Hi Mark

Thanks for the opportunity to comment further. Our response to EG's RfS is as follows:-

Nick Chapman
GreenWay Place Manager

INDICATIVE SUBDIVISION PLAN

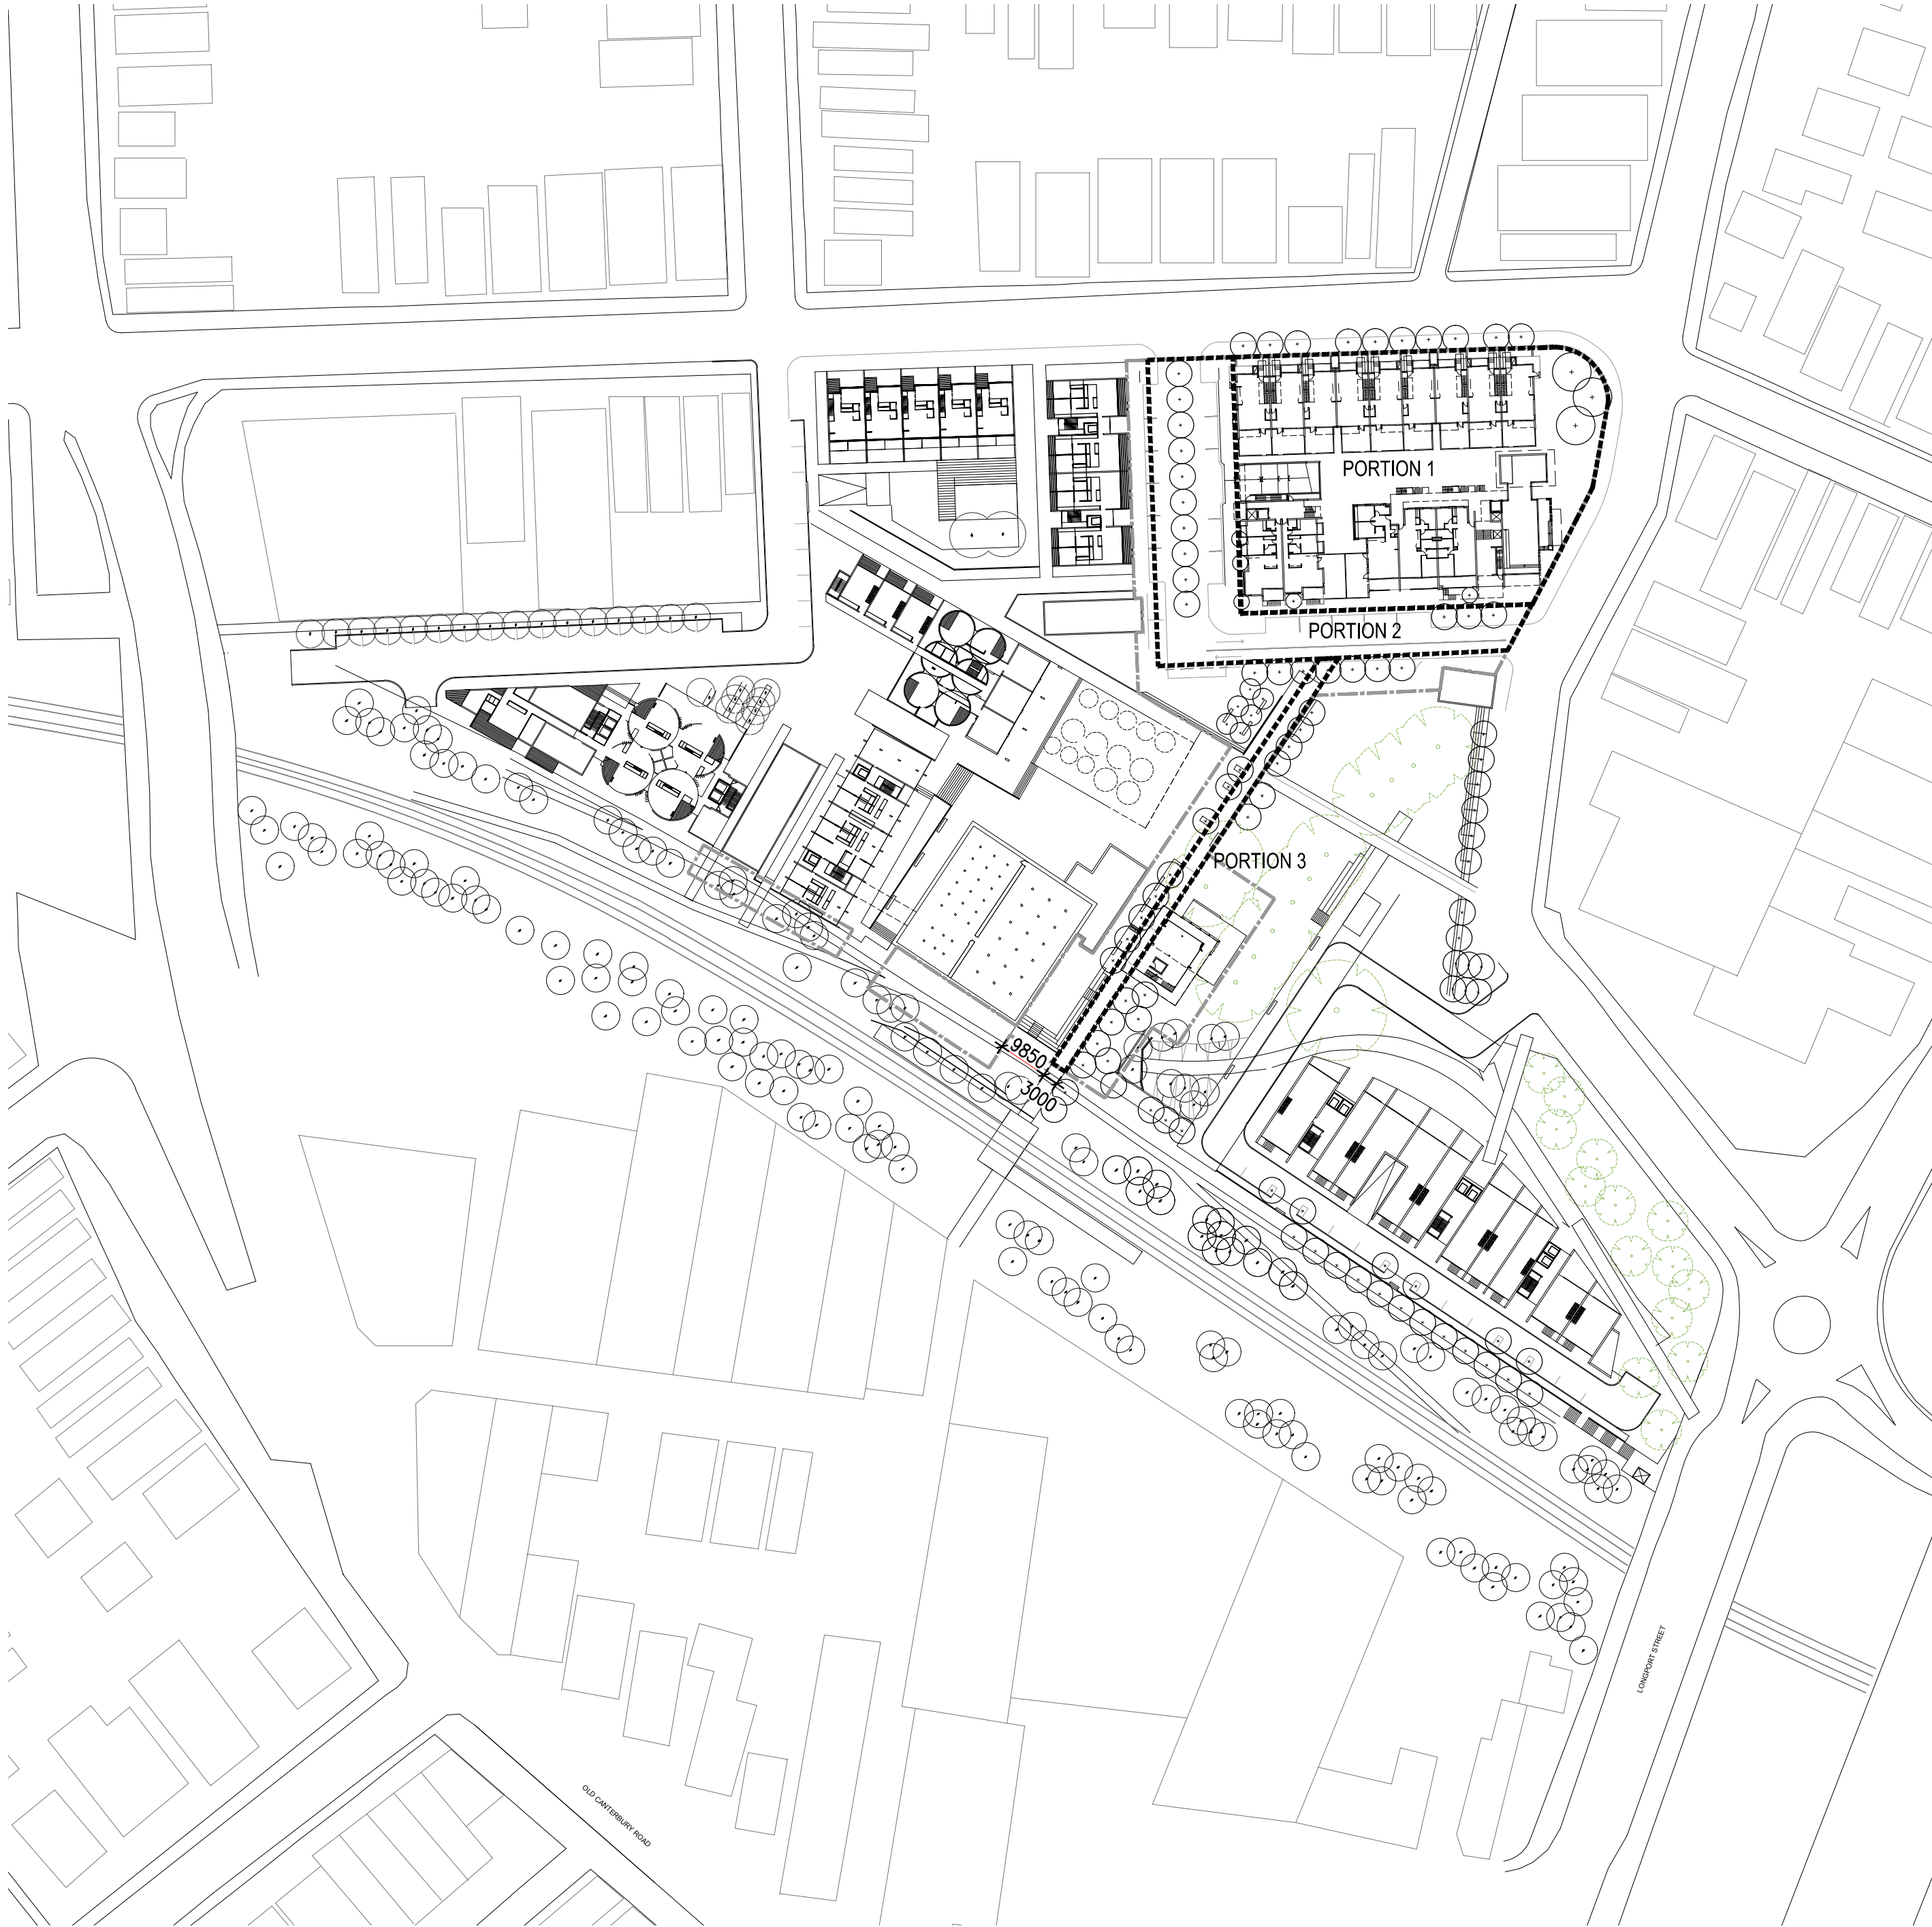
7. Public access through portion 4. It would be reassuring to see this annotated on the subdivision plan.
